January 19, 2023

Gareth Reece
Senior Plans Examiner
City of Mercer Island Community Planning and Development

RE: Permit 2109-150 SUB4 Correction Comment Responses
Site Address: 9611 SE 72nd Street

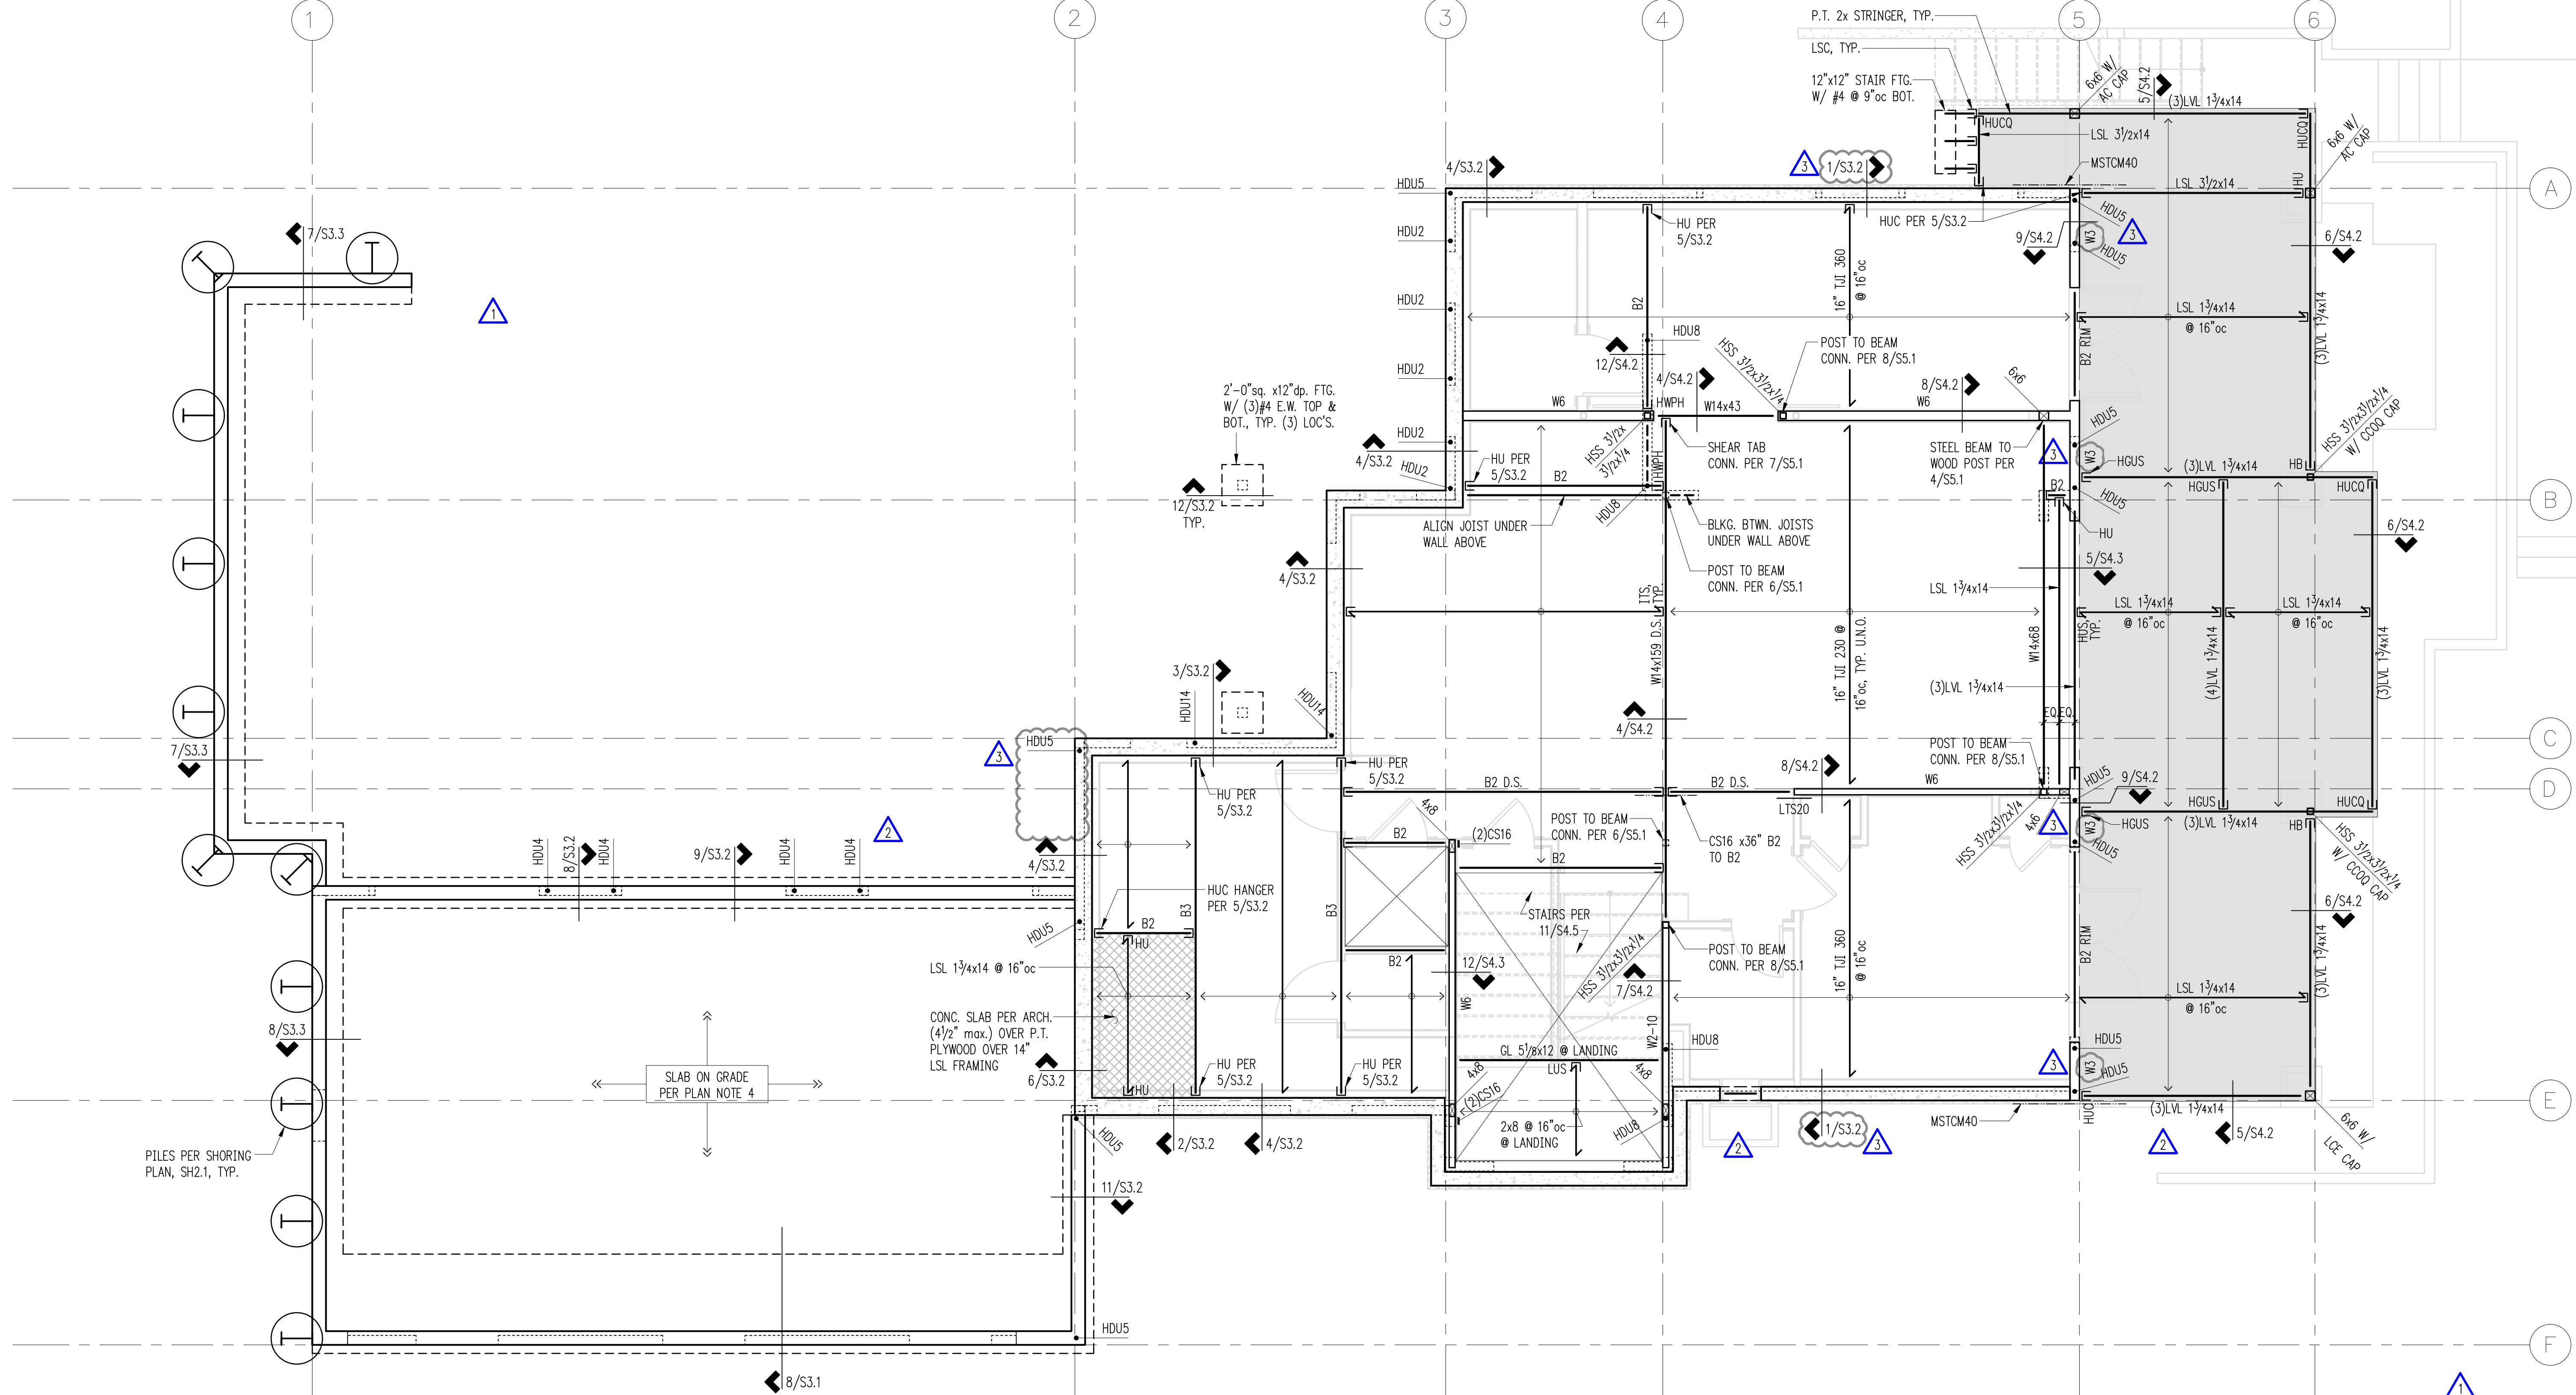
1. Page 9 of 116 of the revised calculations shows that the main floor Grid 5 shear walls should be Type W3 shear walls, but only W4 shear walls are called out on Sheet S2.2 (4 locations). Please revise to coordinate with your calculations.

2. Per page 6 of 116 of the revised calculations, holdowns are required at the upper floor Grid 2 shear walls. These shear walls are shown on Sheet S2.3 and the holdowns are shown on Sheet S2.2. With the slight redesign of Powder Room 206, and the updated lateral design, the HDU5 holdown shown on Sheet S2.2 needs to be realigned to the end of the shear wall. See below:

Response: Please see updated Sheet S2.2.

Response: Please see updated Sheet S2.2.

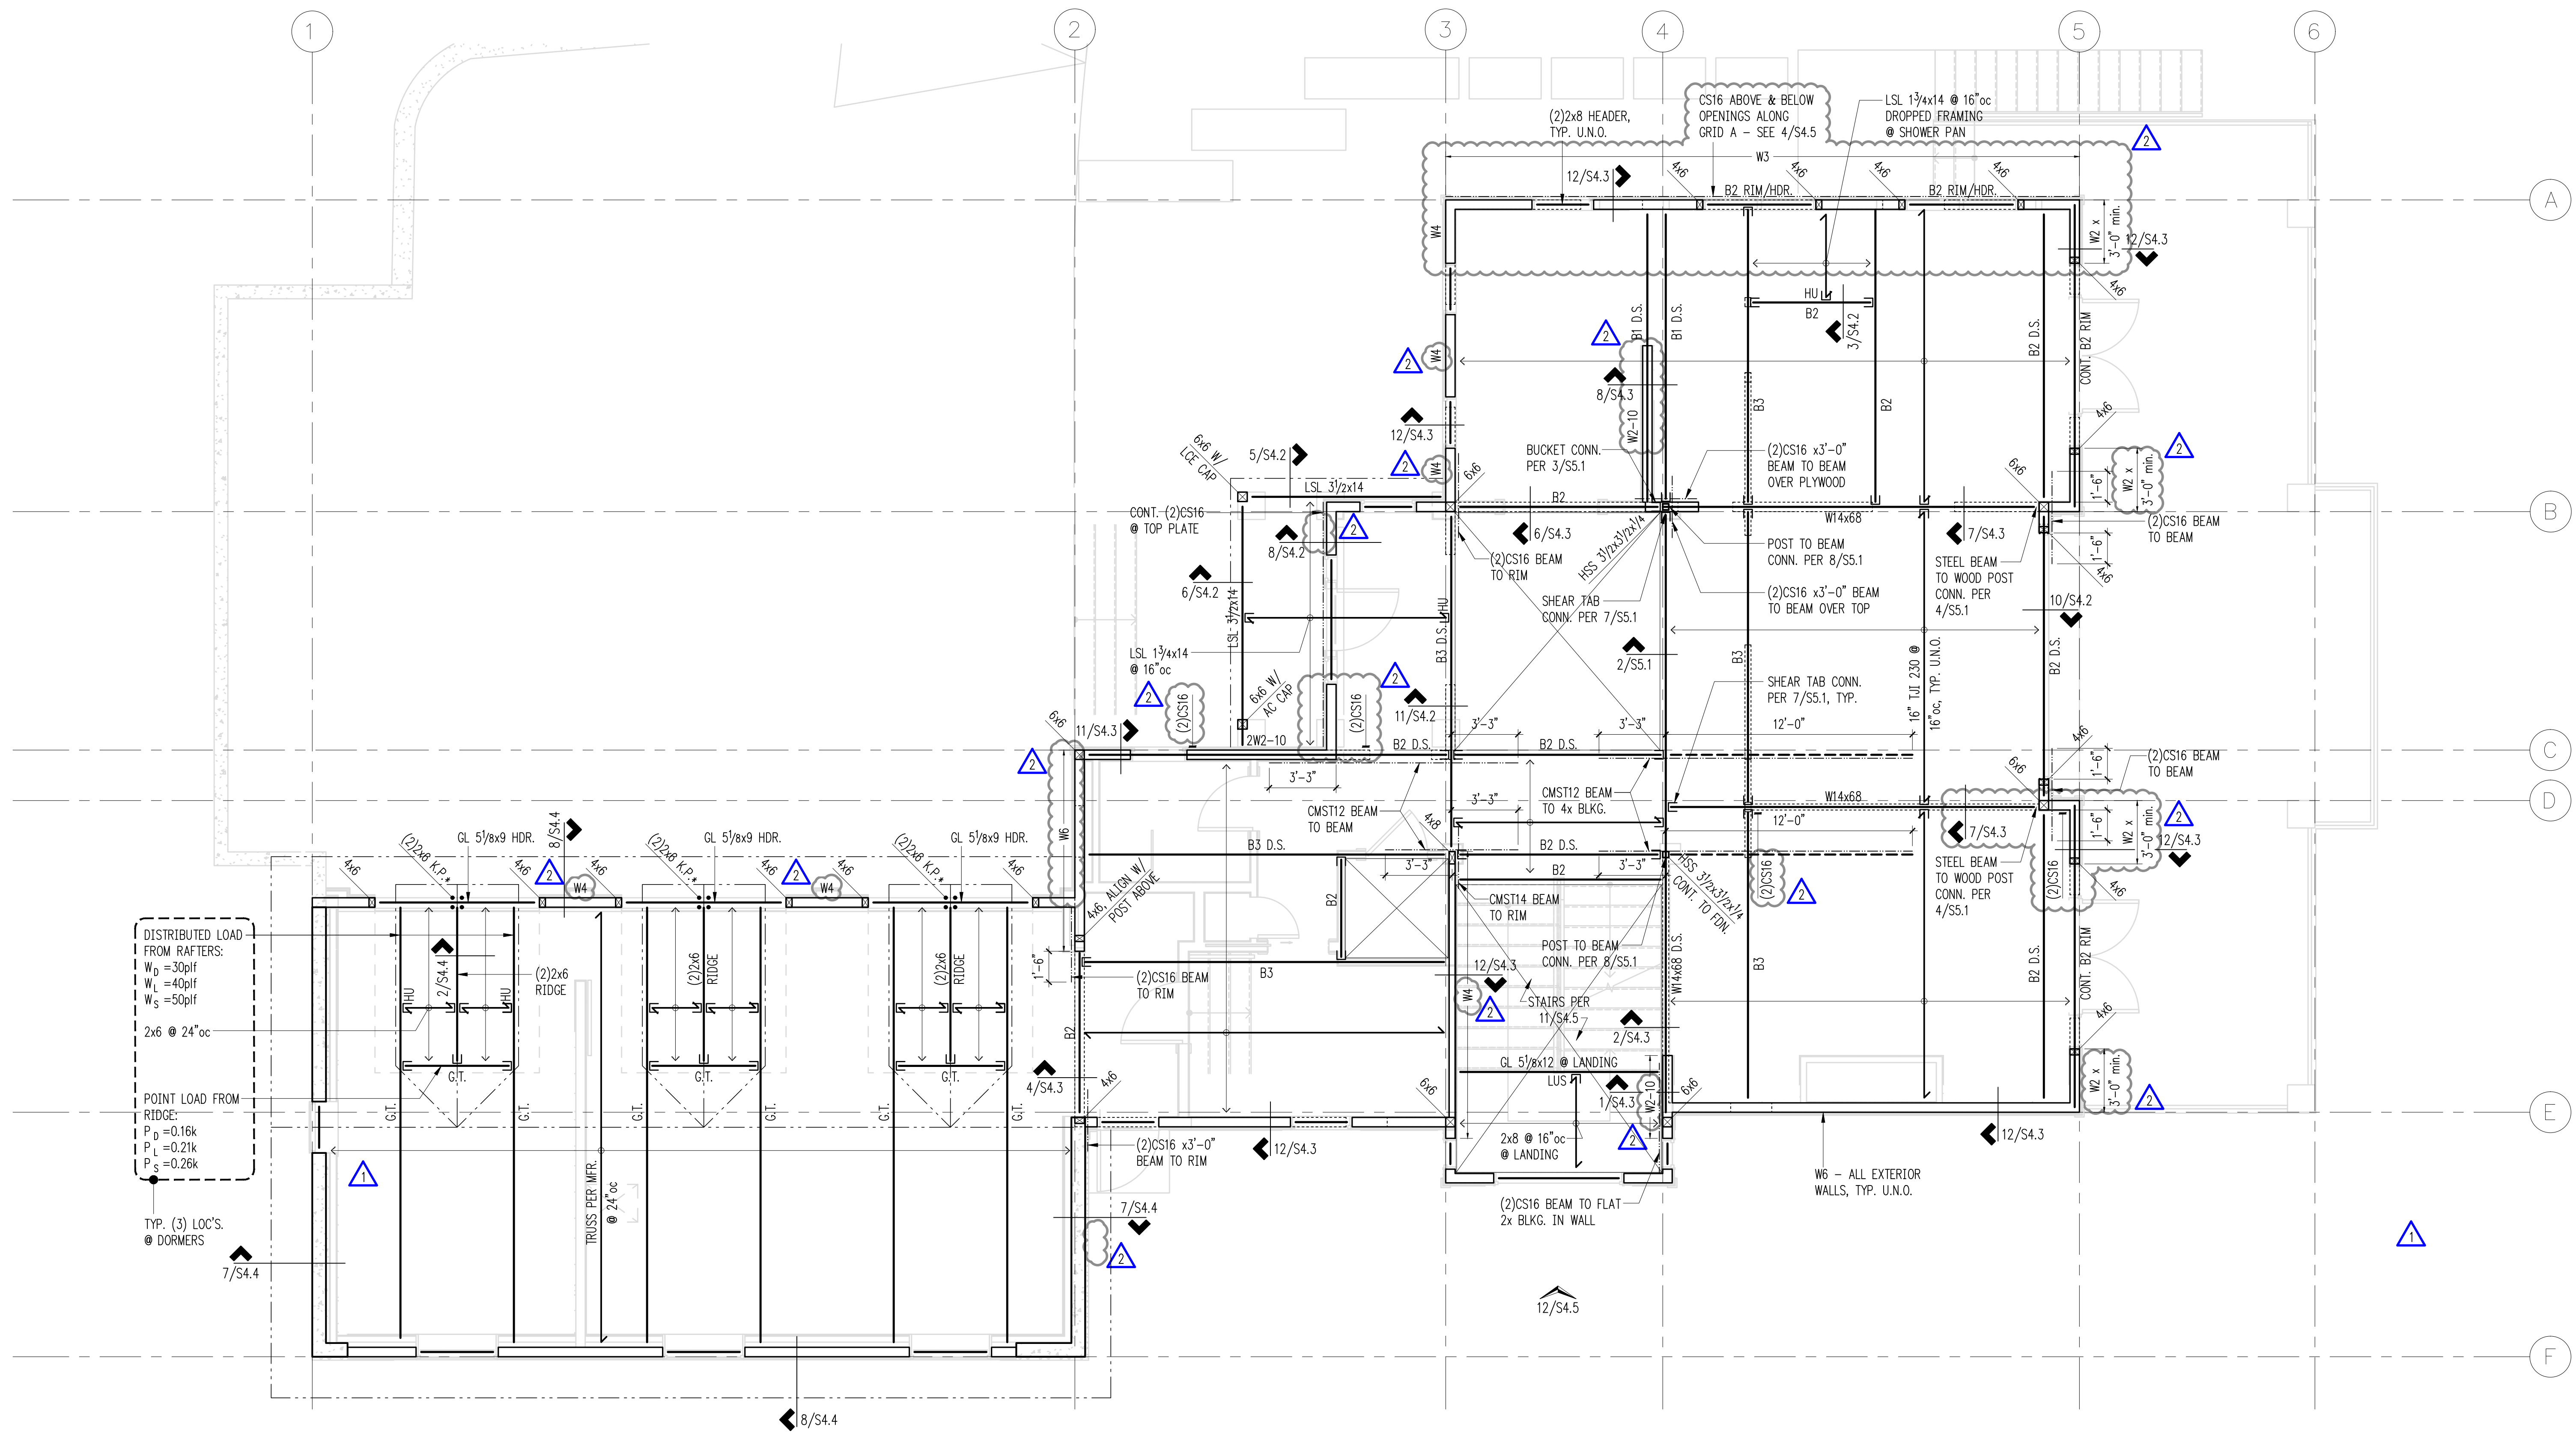
3. Page 9 of 116 of the revised calculations shows that the upper floor Grid 5 shear wall design considering adjustments due to aspect ratio considerations. While the floor height was reduced to 11'-6-1/2" the 3' long shear walls (4 segments) still appear to exceed the aspect ratio limitation in SDPWS 4.3.4. It appears force transfer shear walls will need to be considered. Please refer to the W2 shear walls on Sheet S2.3 and clarify your design.

Response: Shear wall height is measured from bottom plate to top plate therefore $H = 10'-2 \frac{1}{2}"$. 3'-0" length shear walls meet the maximum aspect ratio of 3.5:1.
